**State Significant Development
Submission for the SSD-10260 International Chinese School**

Greenwich and St Leonards Action Group submission – State Significant Development Submission for the SSD-10260

GSL Action Group writes this submission in relation to the State Significant Development Application (SSD – 10260) hereafter referred to as the DA.

SCALE: 1:200 AT A3		ISSUE A
FILE: 19-050	SUPERSEDES SHEET/ISSUE -	
DATE: 27/08/2019		SHEET 1

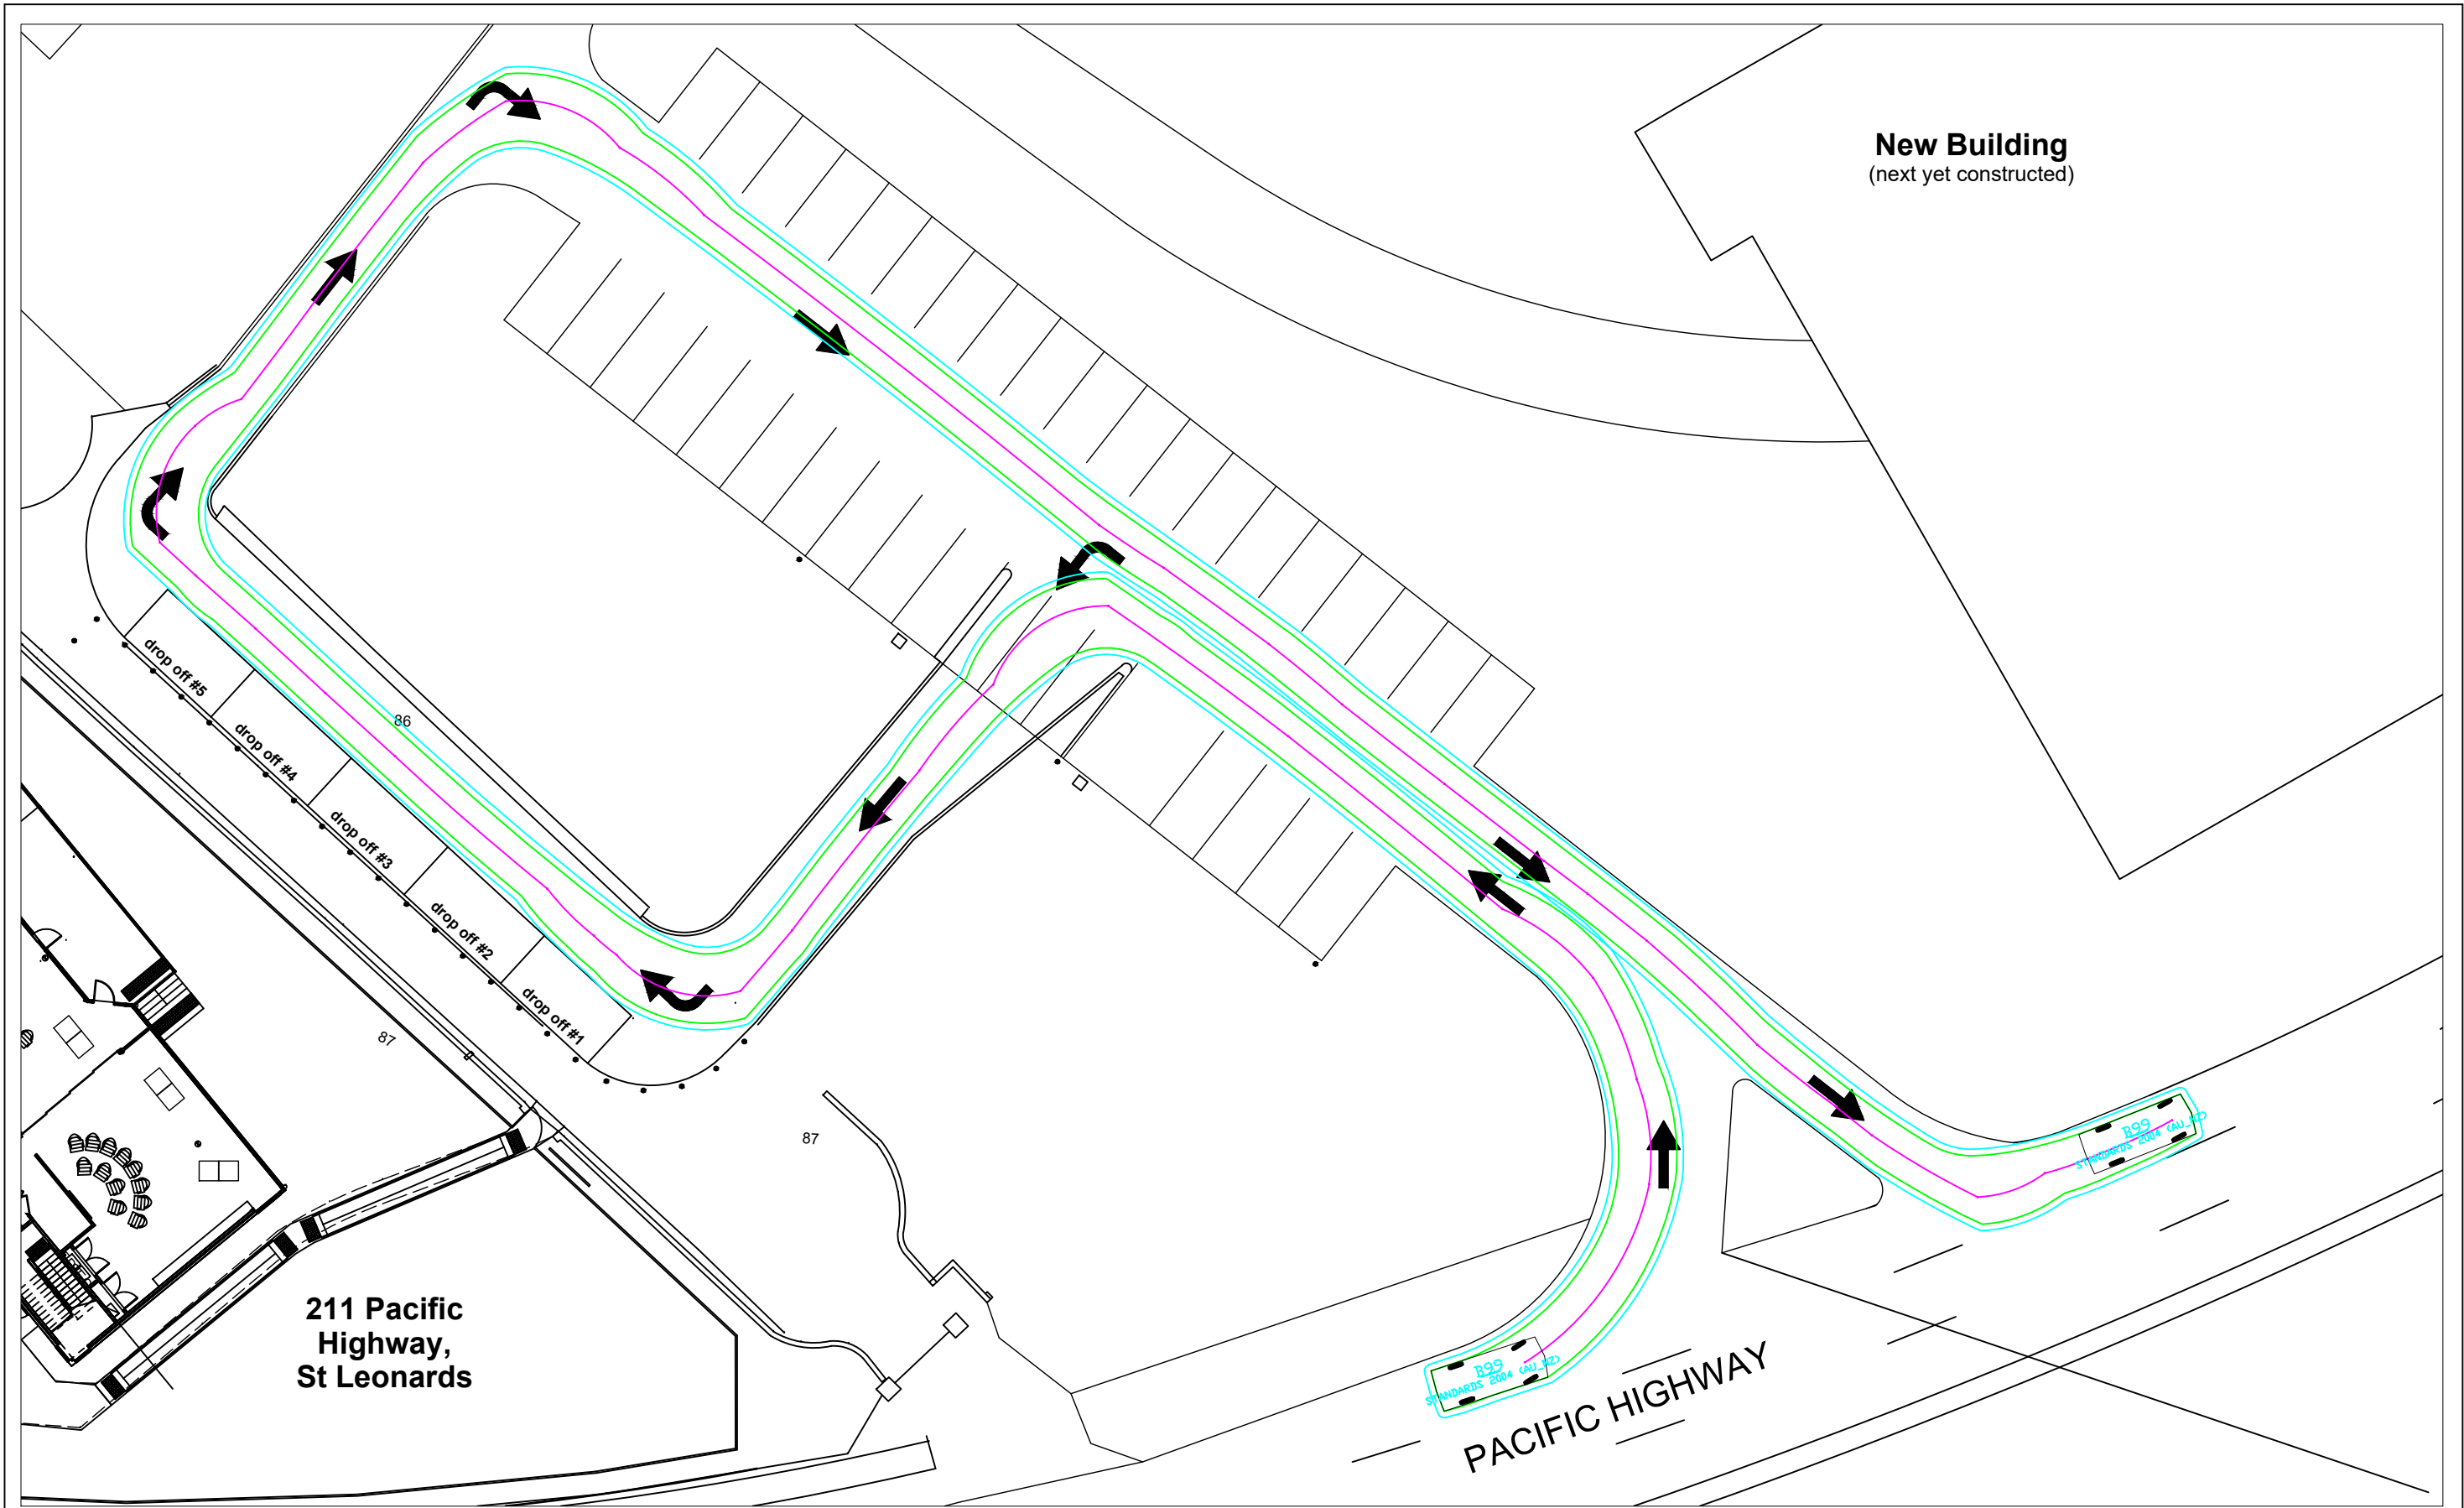
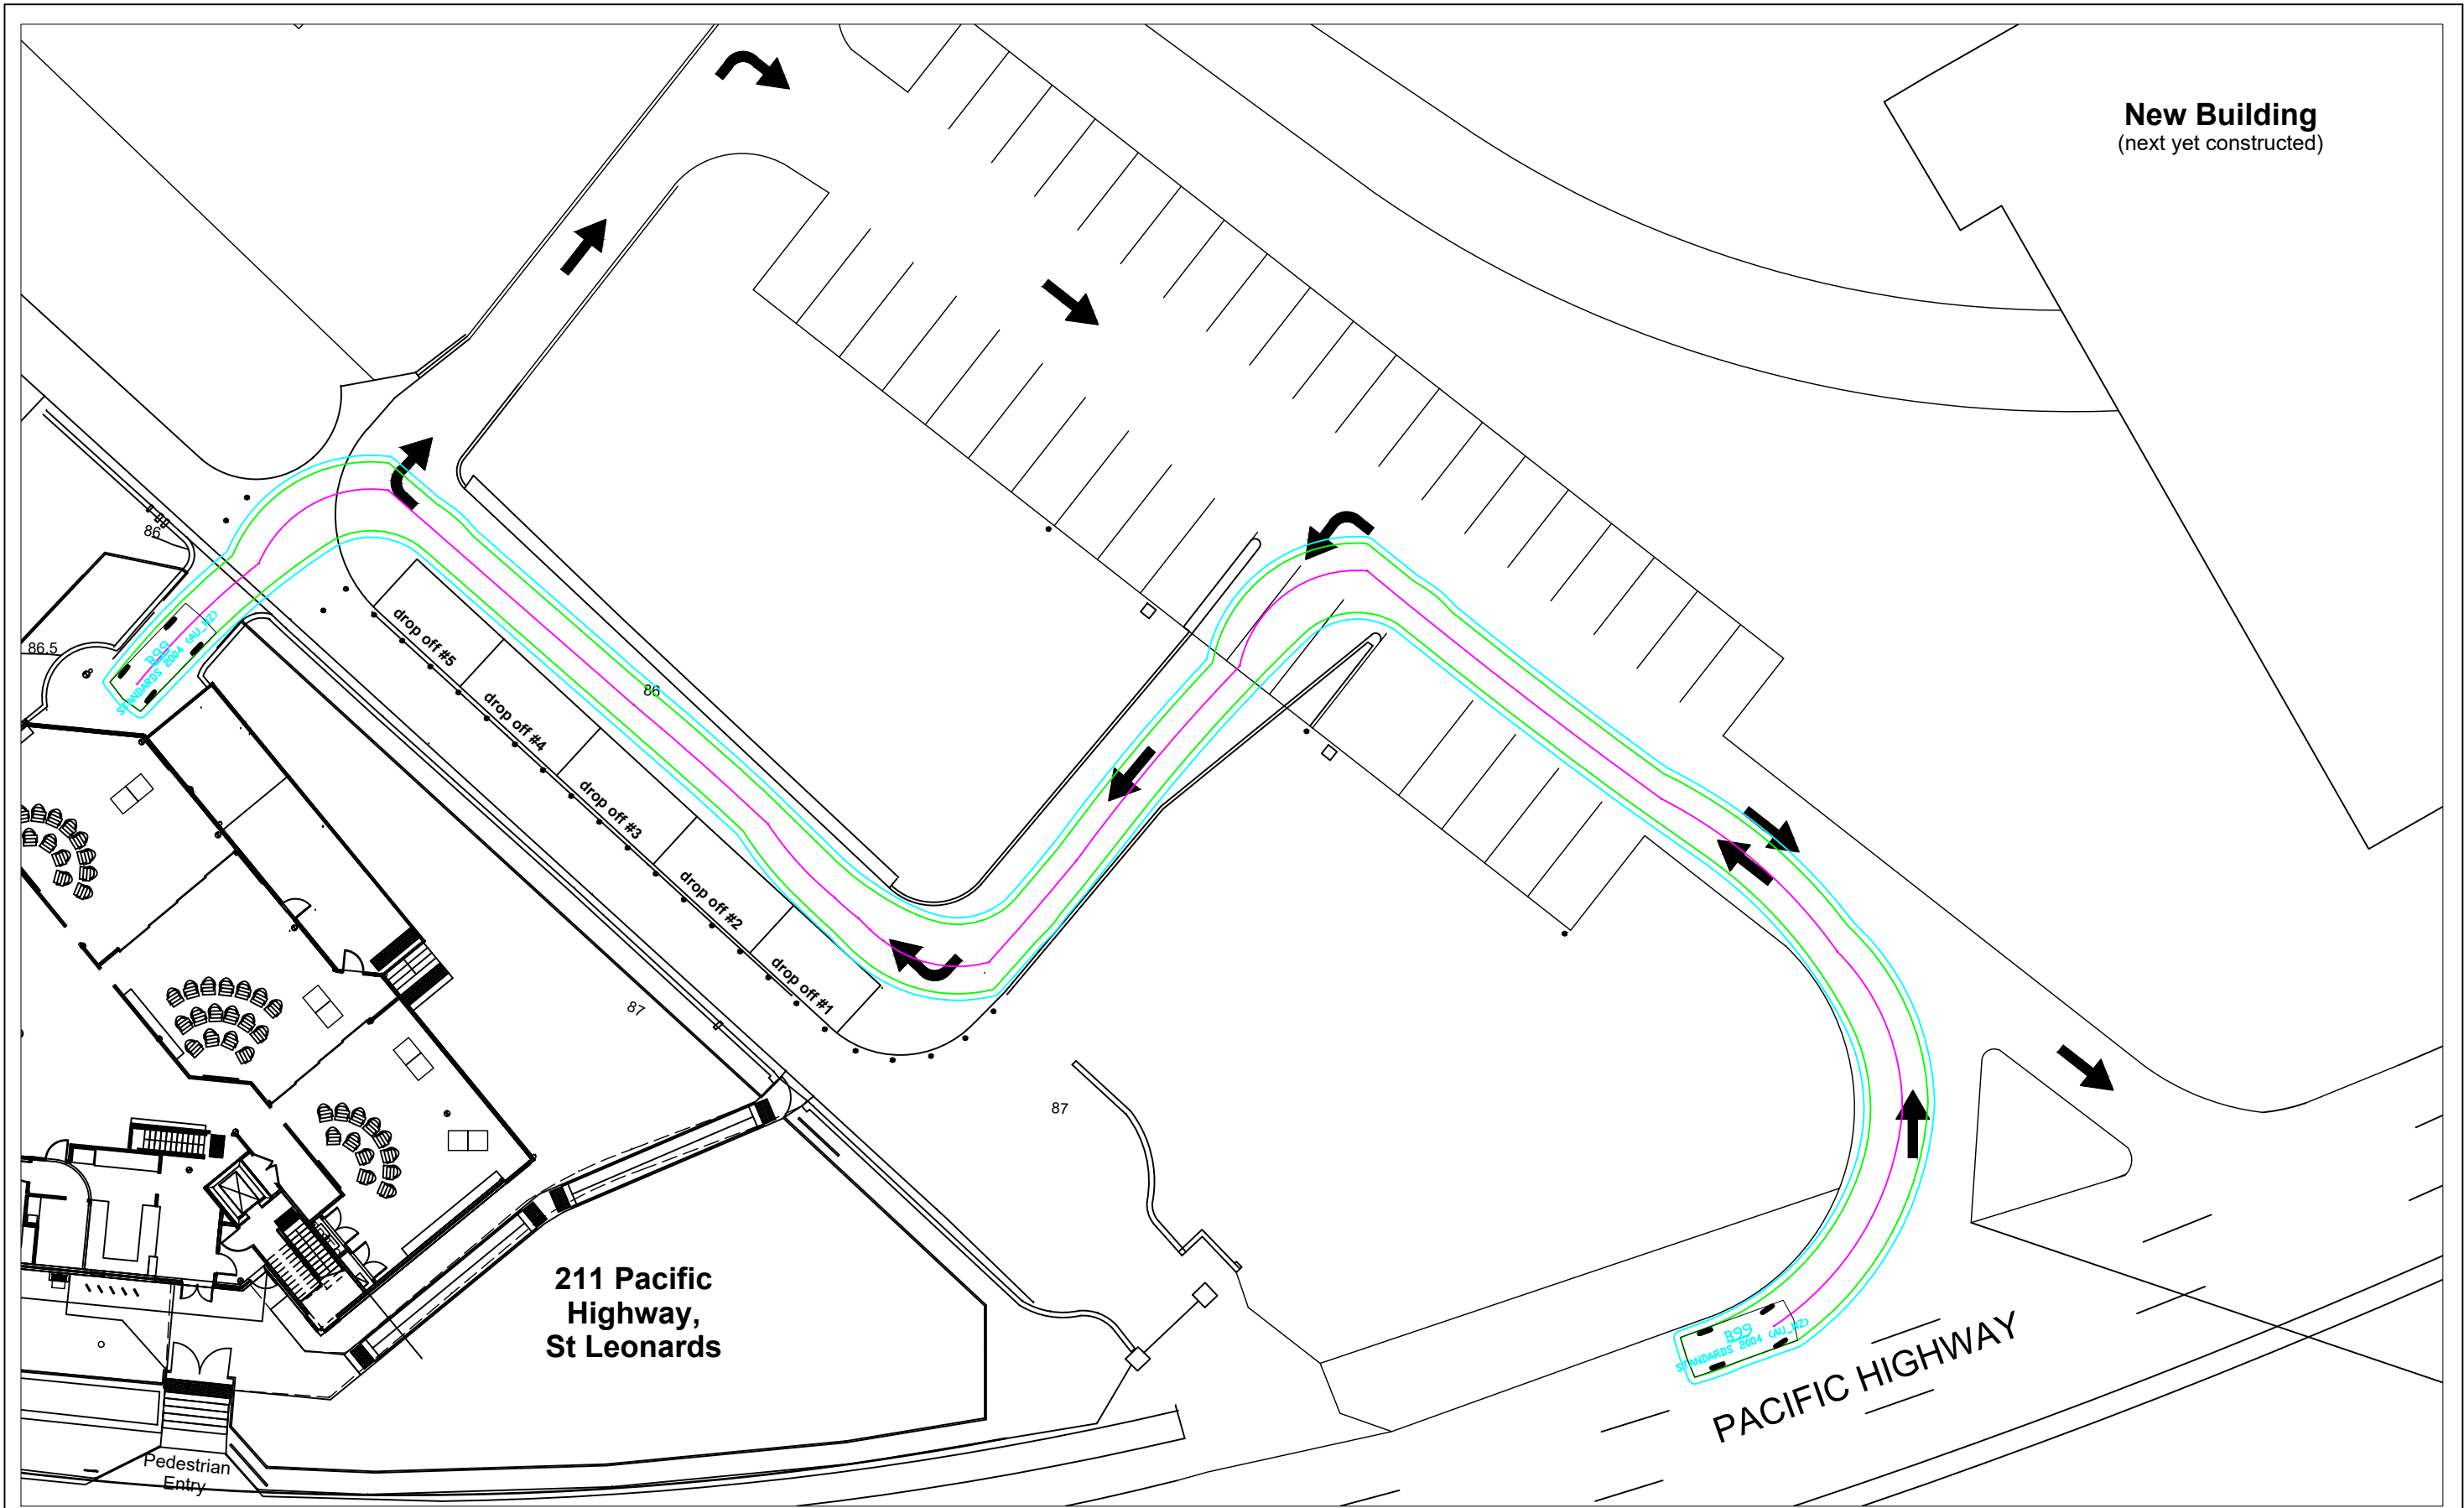
The Stanbury Consulting traffic report conducted by the applicant (dated August 2019) is full of contradictions and conjecture. For instance, the report does not take into account that all the developments “on” the Pacific Highway that will affect the traffic and in turn the DA. The driveway of this DA is “on” the Pacific Highway as such causes delays on the Pacific Highway due to the traffic slowing and starting.

- Traffic constraint will impact immediately adjacent neighbourhood and streets
- Effects on traffic flow from cars exiting and entering the school driveway has not been assessed accurately – it is a blind spot The school traffic will still affect the very congested Greenwich Road and River Road
- Upstream and downstream impacts on traffic on the Pacific Highway and in turn off streets feeding into Pacific Highway impacting Crows Nest and North Sydney
- The precinct does not just stop outside the proposed school and is not an isolated site from the rest of the area
- Vehicle access to the site is impaired
- Congested narrow roads that cannot be expanded
